Your Ref: OWPC16711
Our Ref: BR/305/17/HH 06-11-2017
Please ask for:
Richard Temple

New roof with first floor accomodation & new dormer & new single storey rear extension
30 Mansfield Road Bognor Regis

Thank you for your internet representation made on 21st December 2017 which has been recorded as '**an objection**' with the comments as follows:

PROPOSED ELEVATIONS

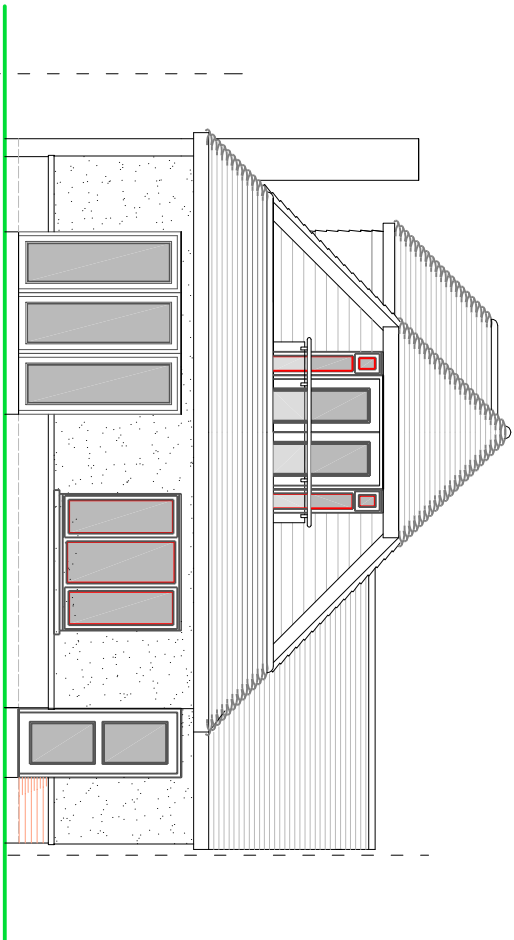
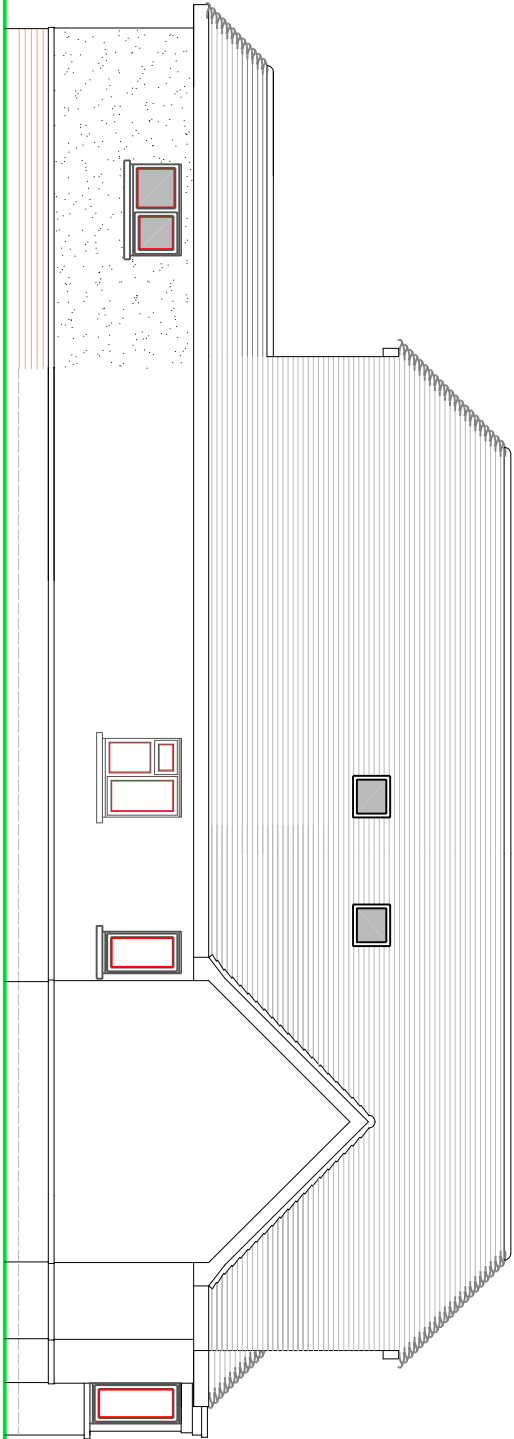
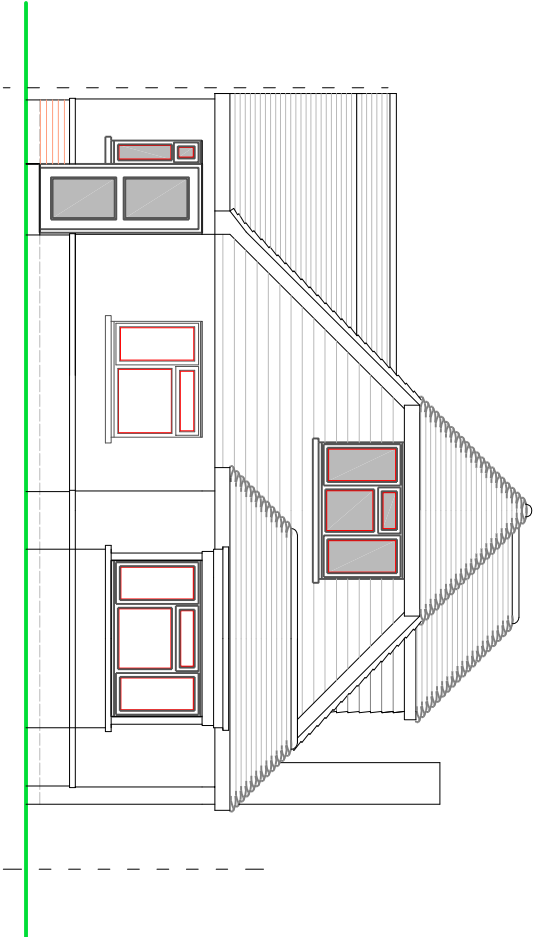
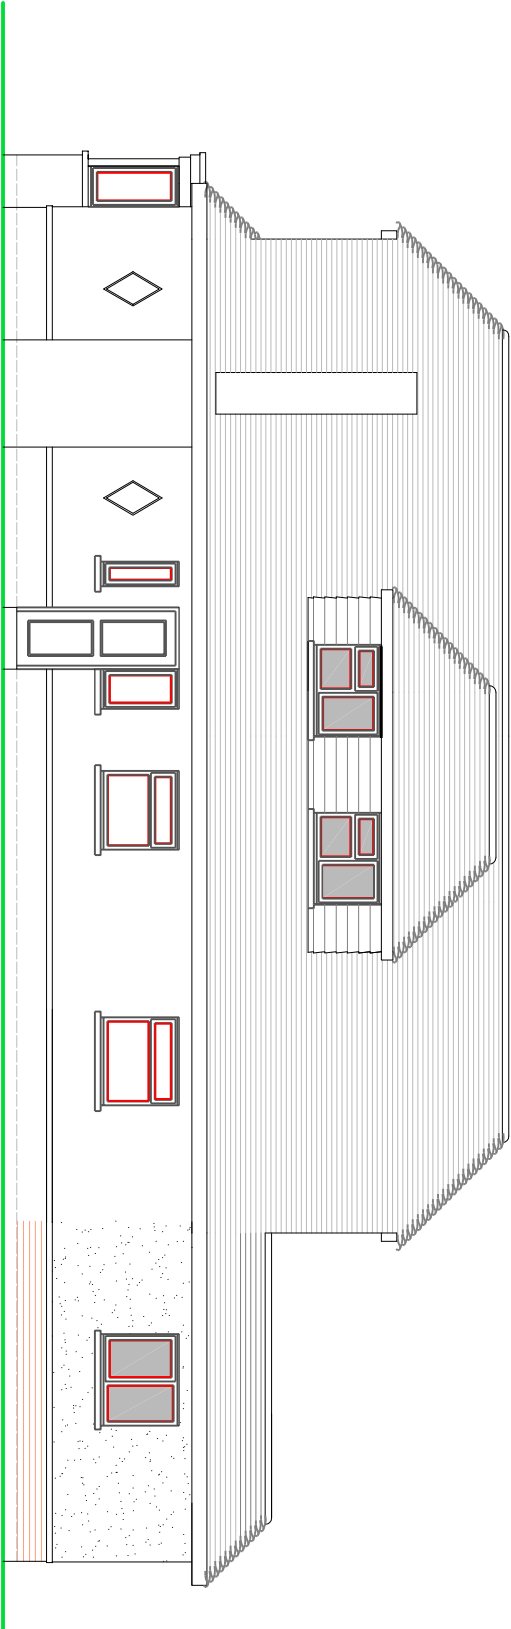
Further to my previous comment, I would like to add that the dormer on the south side would give the appearance of the building being a house from our property. I have looked around the surrounding area and loft extension's on bungalows have been done with velux windows in the roof so as not to spoil the street scene.
